RIBBLE VALLEY BOROUGH COUNCIL

Officer:	Rebecca Bowers	Tel:	01200 414518	Council Offices Church Walk Clitheroe Lancashire BB7 2RA	
Email:	Rebecca.Bowers@Ribblevalley.gov.uk				
Our Ref:	RV/2018/ENQ/00029				
Proposal:	Proposed first floor side extension over single storey garage and single storey rear extension with covered balcony.			Tel: 01200 425111	Fax: 01200 414487
Date:	1 st May 2018

Pre-Application Enquiry Response

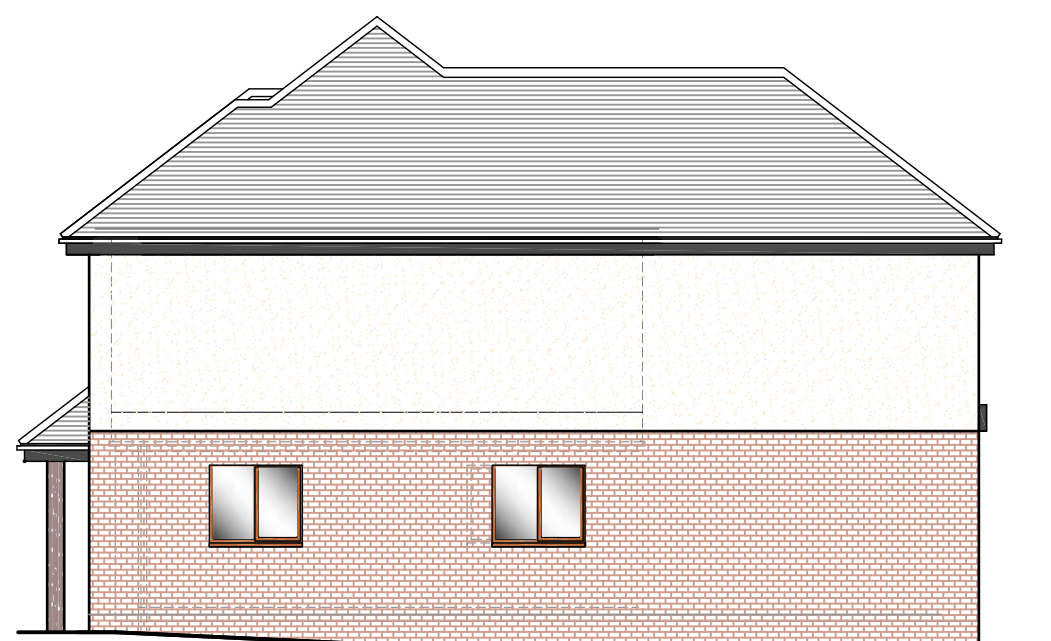
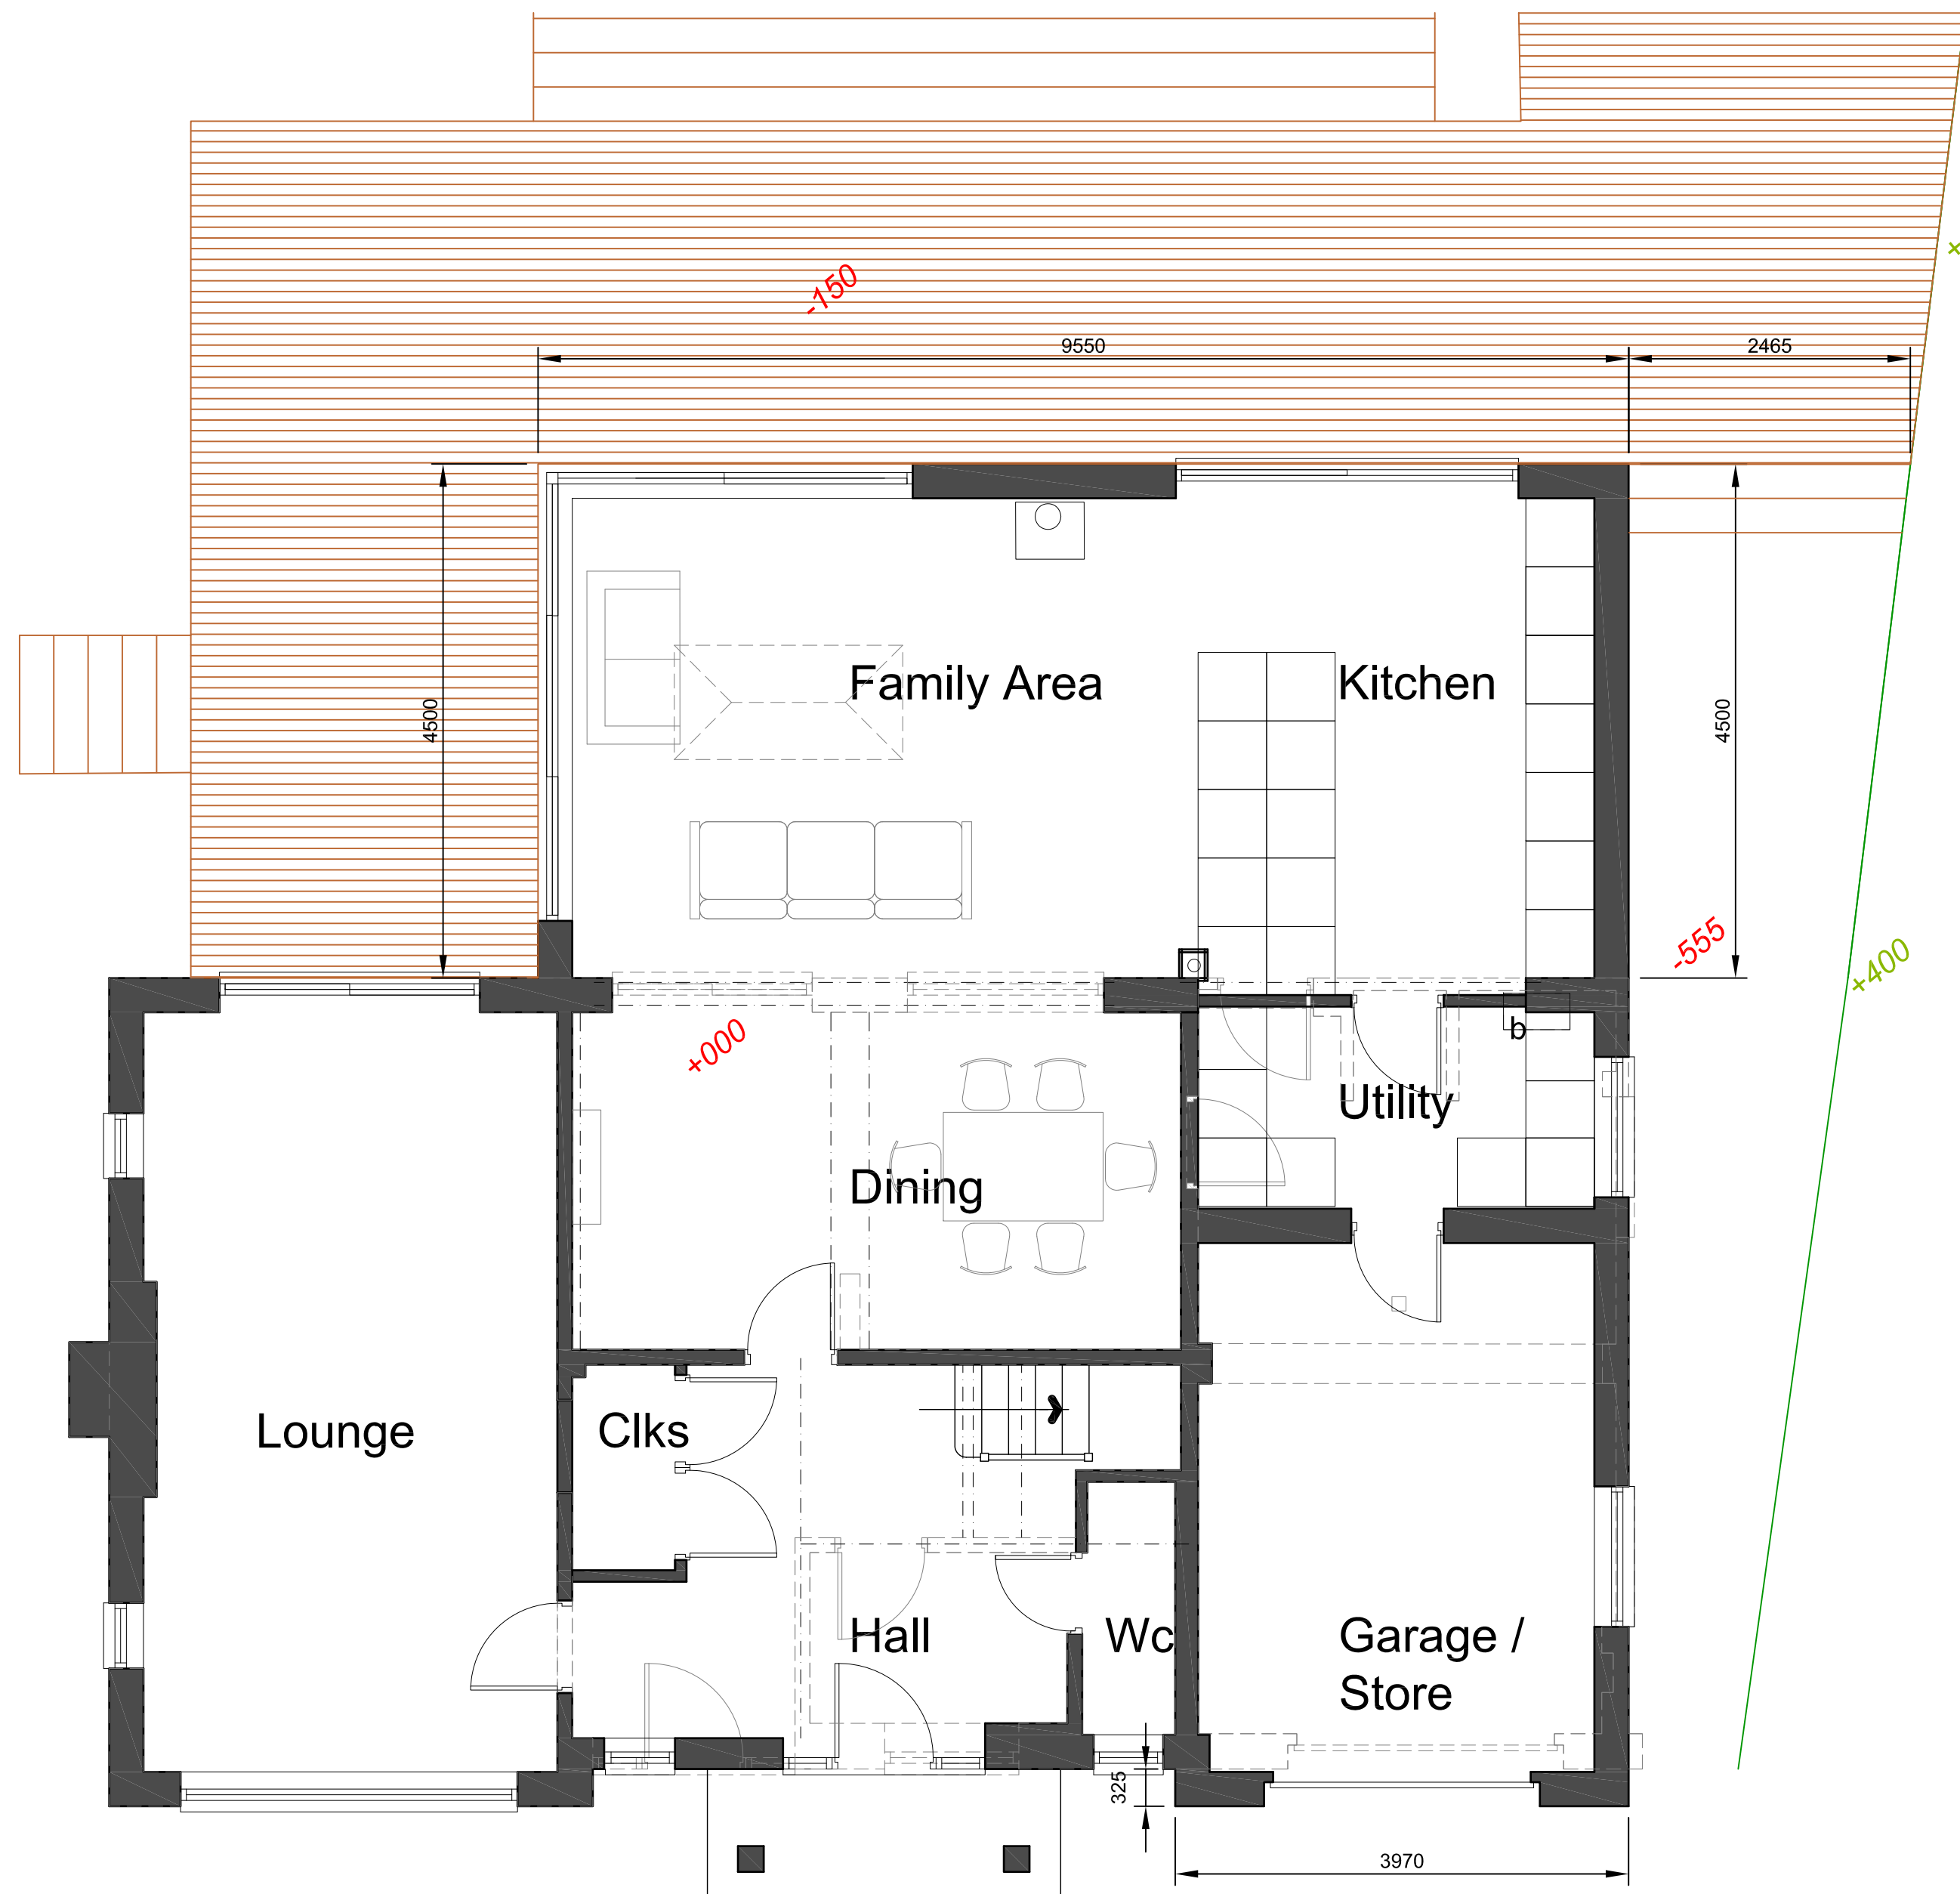
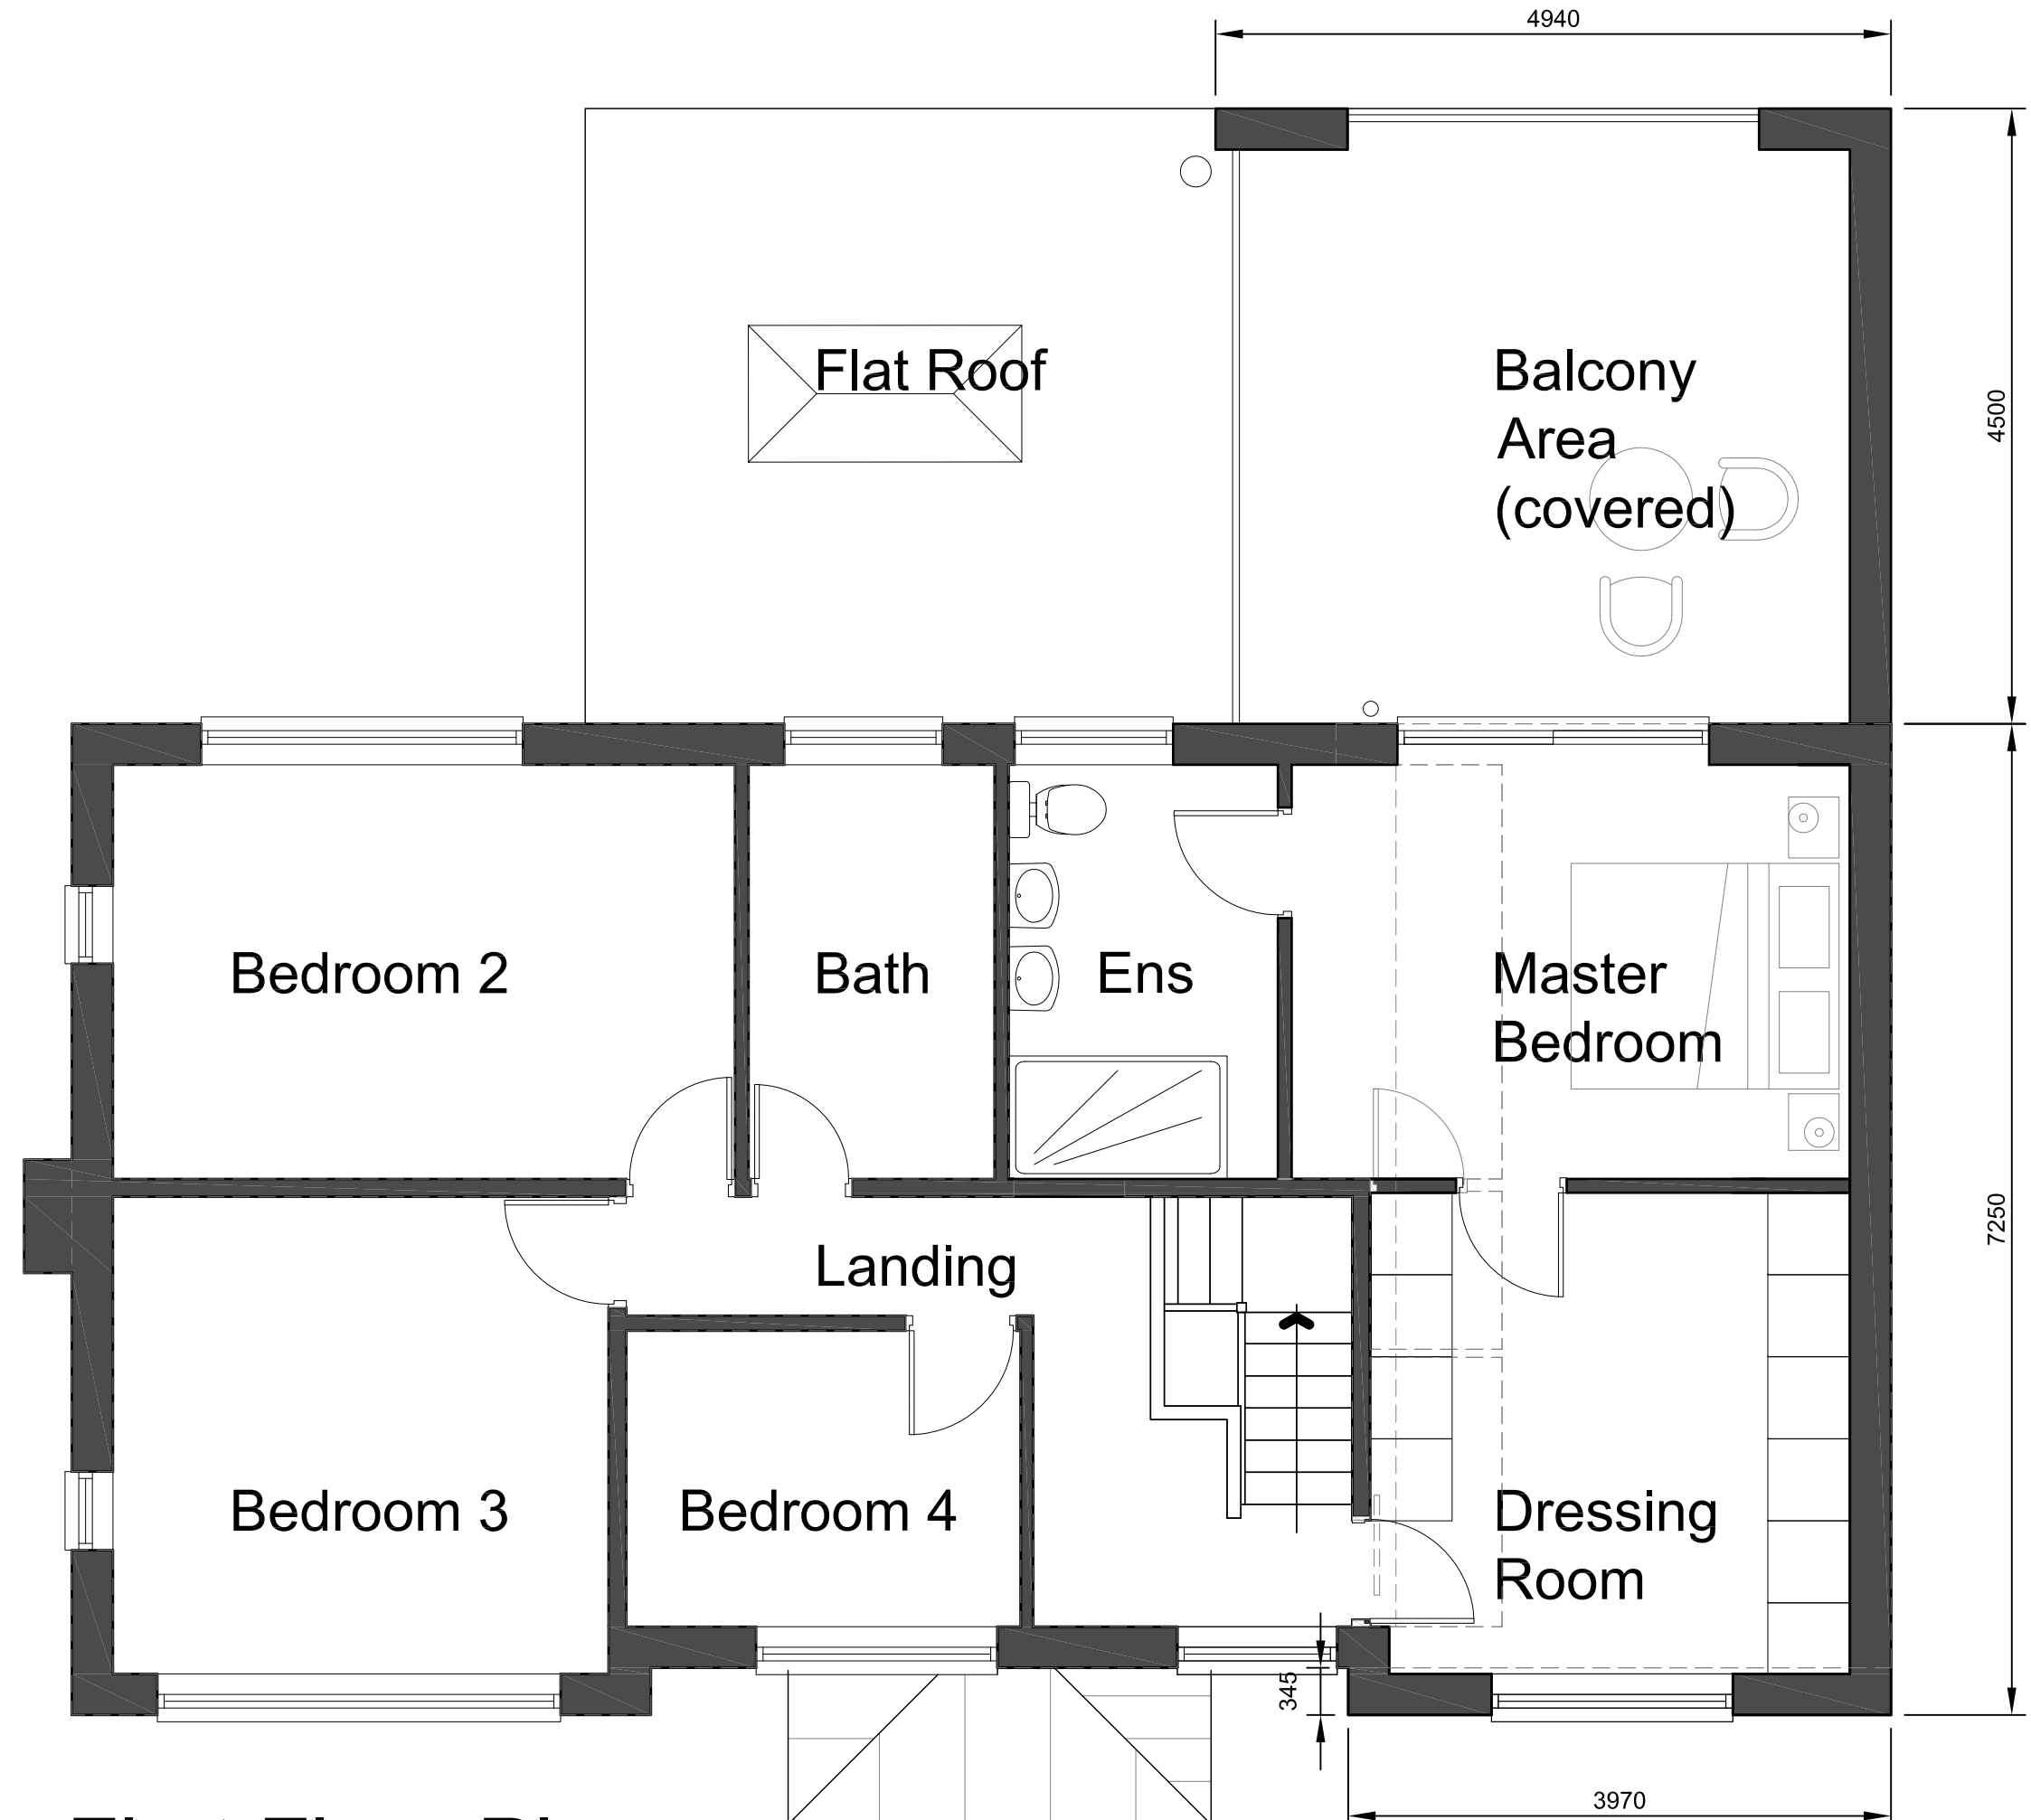
When considering the rear extension the Council would expect a 21m separation distance between principal elevations, this distance has been met as the property backs onto open land and therefore I consider it to be in accordance with policy DMG1. The first floor extension above the garage is also considered acceptable as side elevation at first floor will be over 2 metres from the boundary and the windows in the side elevations of no 16

appear to be serving non habitable rooms and therefore the impact of the extension is unlikely to be over bearing or lead to loss of light on the property. However, as part of any formal application we would consult with the neighbouring properties and should any of windows be serving habitable rooms the impact of the proposal on these windows will be a serious concern. The extension has no window planned for the (side) elevation, and so does not raise any concerns with regards to privacy or overlooking.

Although the proposed first floor extension will alter the style of the existing property I consider that the proposed scheme will balance out the existing roof and as the surrounding properties vary in size and design, I consider there will be limited harm to the visual amenity of the area.

In summary I have no objection in principle to the extensions as proposed on the plan submitted and would expect the proposal be recommended for approval if submitted.
